Application: SSI 7485

I write regarding the proposed modification to M4-M5 Link, Mod 2 The Crescent overpass and changes to pedestrian infrastructure in North Annandale, Rozelle and Rozelle Bay Foreshore area. *I object to the modifications proposed*

**Figure 4 | Proposed modification** (Source: Design Amendment Report)

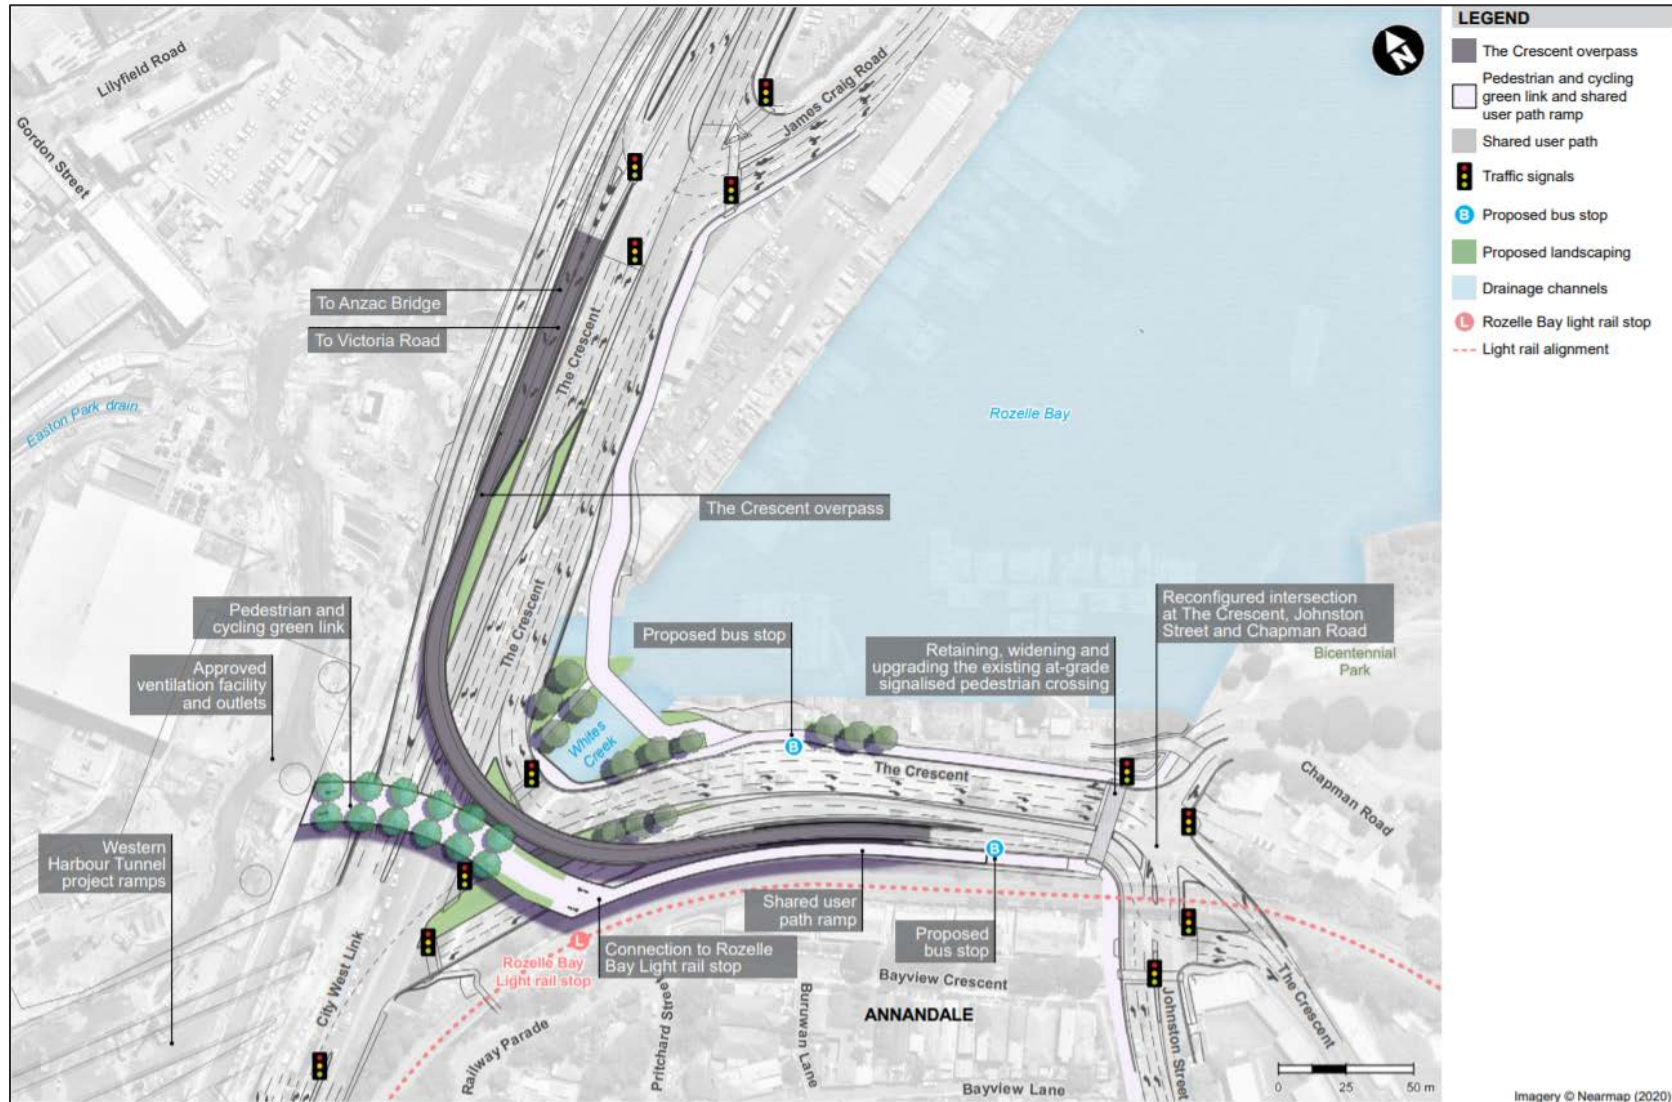
- The significantly reduced safety and increased risk for pedestrians and cyclists with removed access over The Crescent to Bicentennial Park and the increased traffic along Johnson Street.
- Being required to cross five sets of pedestrian lights at The Crescent as my option to reach the foreshore from Annandale or from Rozelle Bay light rail stop.
- Removal of direct active links to the foreshore, cutting the community off from the area and the proposed revitalisation of the entire Bays Precinct, including linking the Light Rail and Bus stops to a Ferry wharf and Metro station.
- Urban and landscape design that is being built before a finalised Masterplan for the area.
- Traffic changes that limit movements around the suburb and create further congestion in the local streets of Annandale, Forest Lodge, Glebe, Lilyfield and Rozelle with no planning to deal with these.

- *the sheer ugliness of the overpass and concrete plaza*
- *the deceit and contempt for citizens demonstrated by RMS in proposing such a radical design post initial approvals. I have always been a supporter of Westconnex but I find Mod 2 to be very unjust & ill thought through.*

- Reinstate the GreenLink connecting communities and green open space from Rozelle to Bicentennial Park
- Relocate and design pedestrian and cyclist connections that are continuous, safe and direct.
- Design the modification infrastructure and active links in response to the character of the suburbs, the location of the foreshore and it's potential future development.
- Provide pedestrian and cyclist paths that maximise people safety and do not force them onto busier streets, unsafe concrete plazas and caged walkways.
- Integrate active and direct connections to all active transport – including the future Metro West and Foreshore Ferry Wharf
